From: Brown, Sophie [REDACTED]
Sent: 03 February 2016 15:11
To: Richard Temple
Subject: RE: BN/29/15/PL - Barnham Court Solar Farm

The proposed development will only meet the requirements of the National Planning Policy Framework if the following measure as detailed in the Flood Risk Assessment ICBR0039_FRA- Rev 00 20th July 2015 and subsequent drawings (2768_04 Rev A & 2768_03) submitted with this application are implemented and secured by way of a planning condition on any planning permission.

FIGURE 13
Typical panel elevations

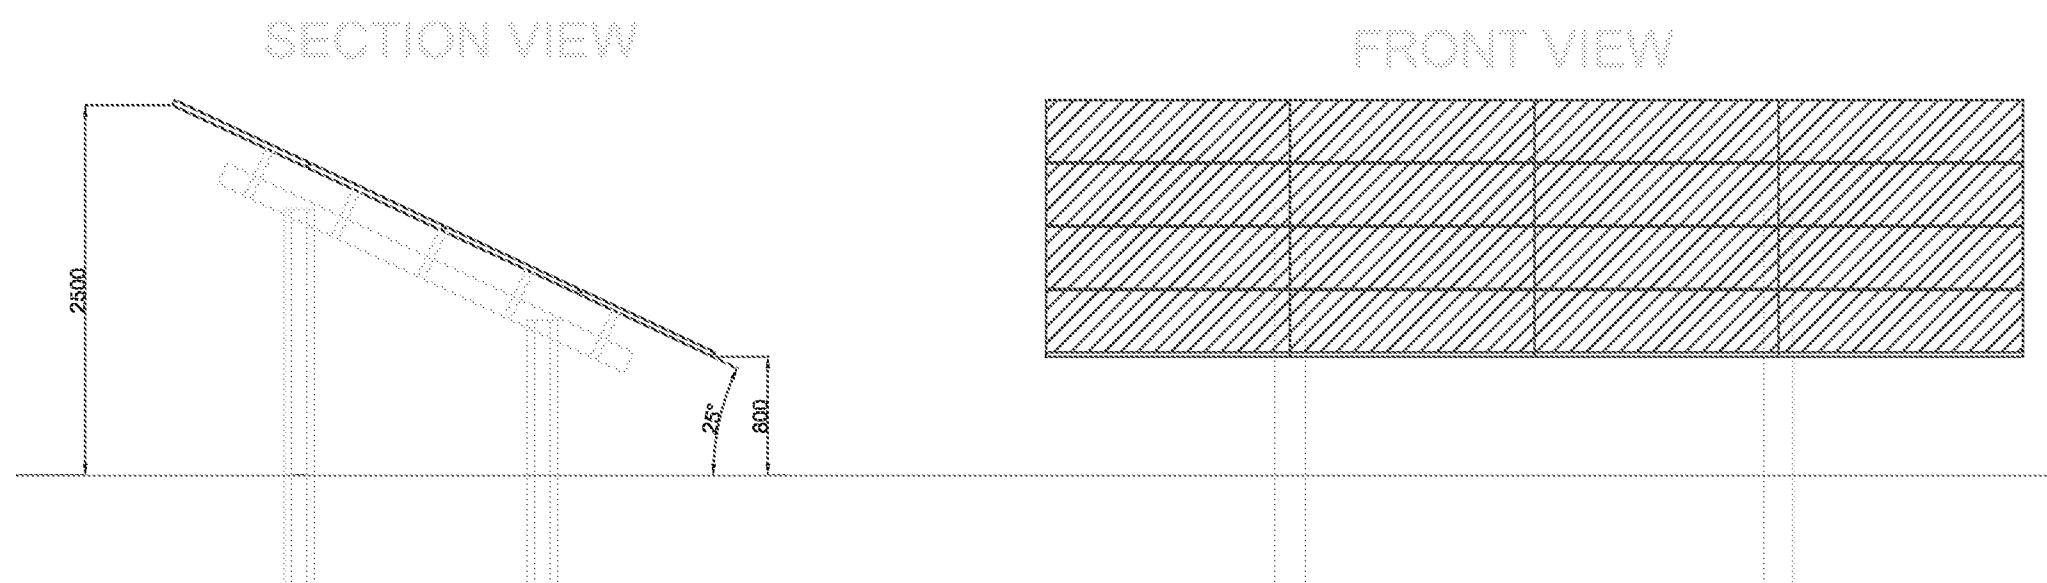
- As detailed within drawing 2768_04 Rev A (dated 1/02/2015), the lower edge of the panel should be no lower than 1.3m above existing ground level (2.3m above Ordnance Datum (AOD). This is in line with the flood level of the 1 in 100 year plus climate change (1% Annual Exceedance Probability plus 20% allowance for climate change).

The development permitted by this planning permission shall only be carried out in accordance with the approved Flood Risk Assessment (FRA) along with drawings 2768_04 Rev A and 2768_03) and the following mitigation measures detailed within:
